Our Ref: EP/37/20/HH
Your Ref:

Town & Country Planning Act 1990 (as amended)
Town & Country Planning (Development Management Procedure) (England) Order 2015
Application for Planning Permission for Works or Extension to a Dwelling

Development Single storey side/rear extension, part two storey rear extension rear extension, raising of roof height to create a second floor and front double garage.
Location 56 Angmering Lane Rustington

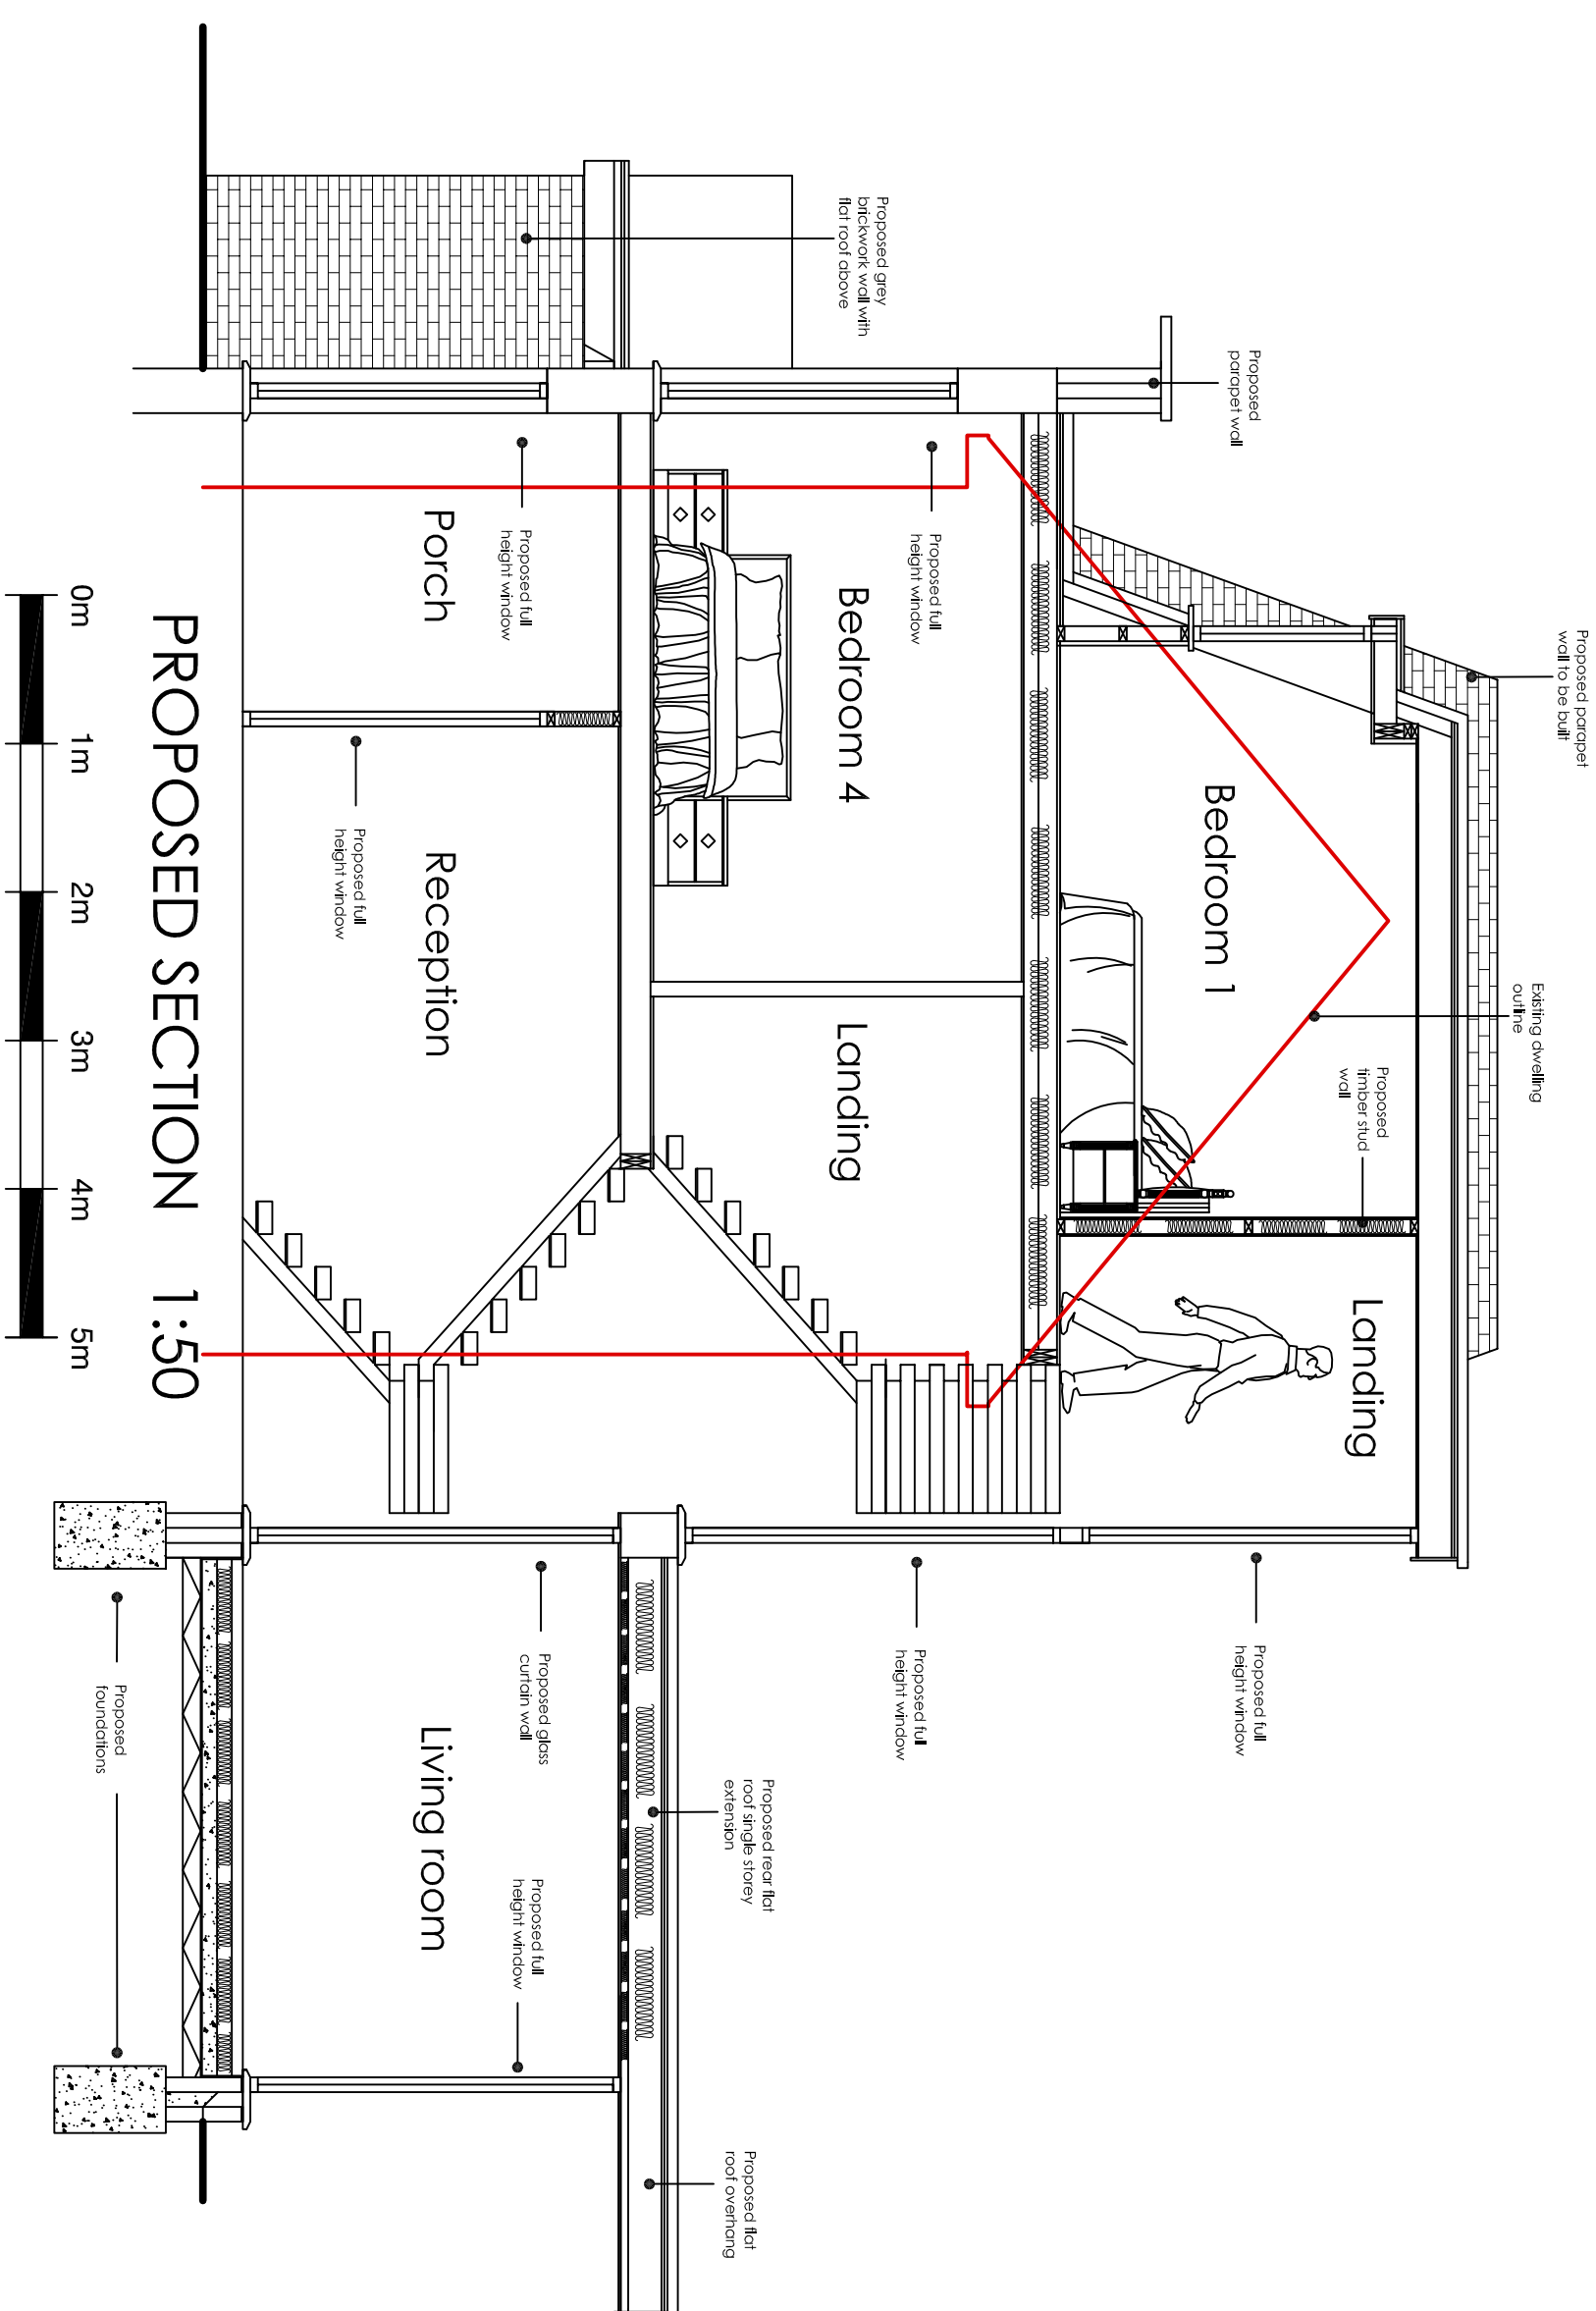
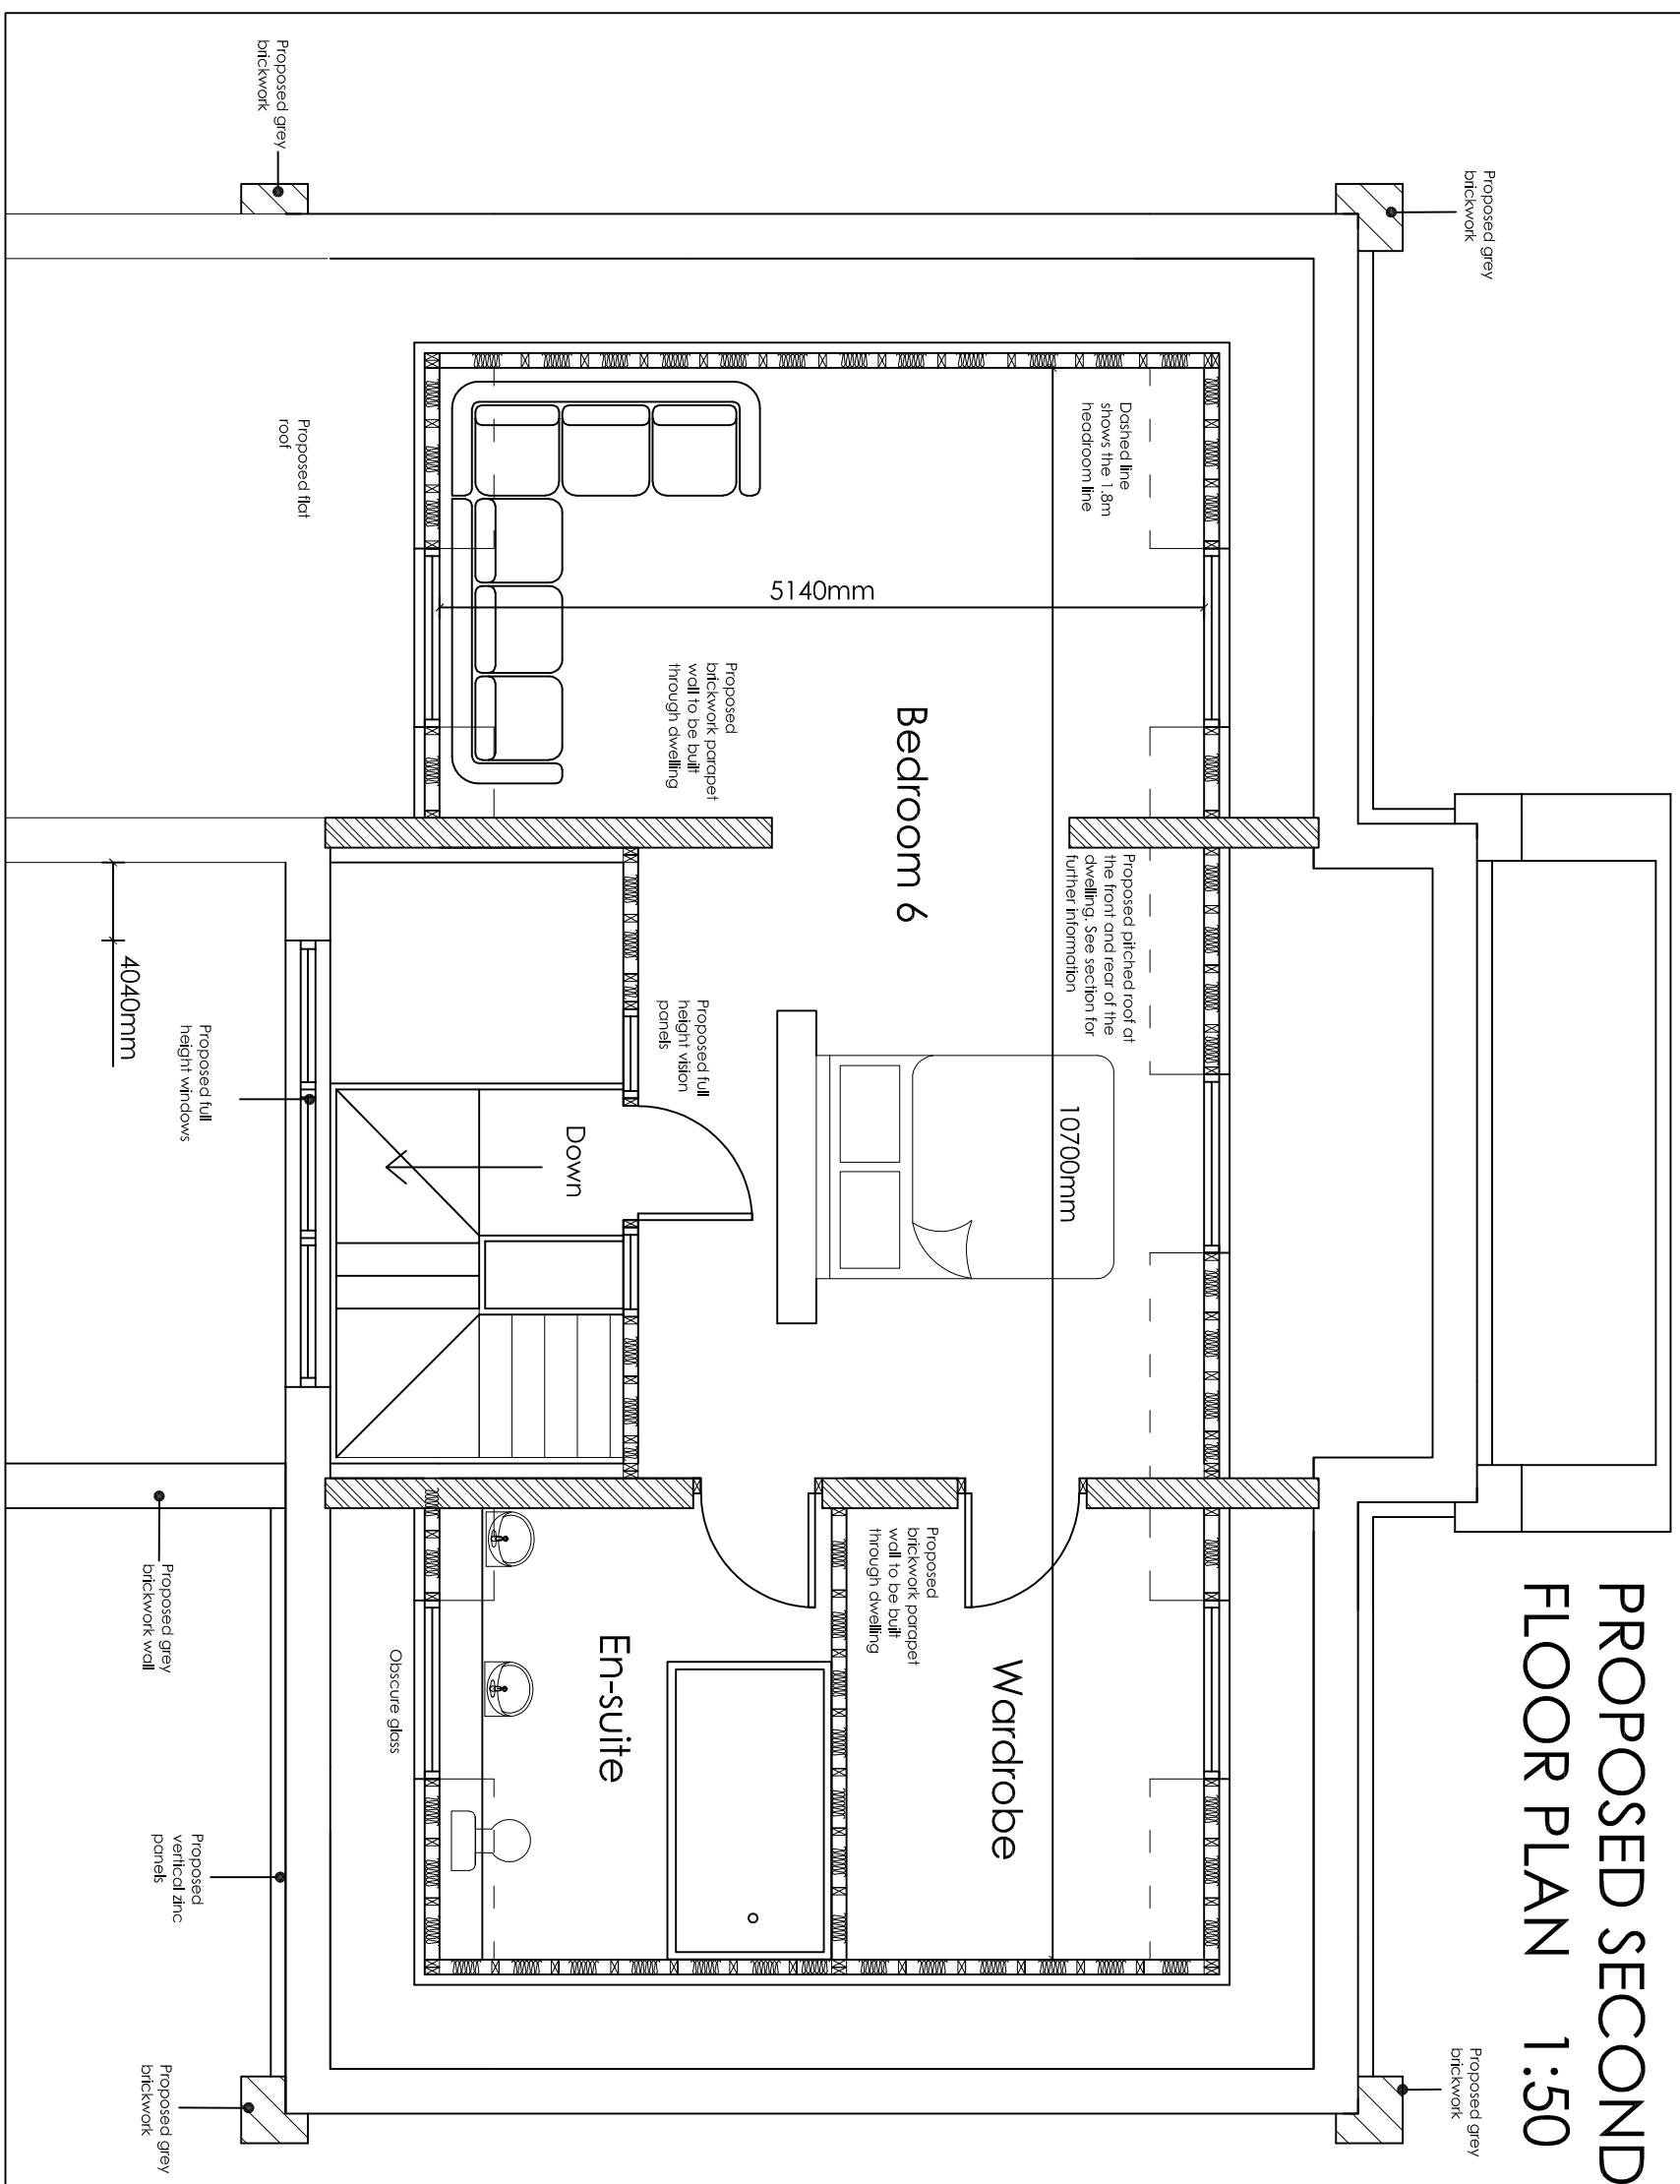
The width of the second floor does not match between the proposed floor plan and elevations.
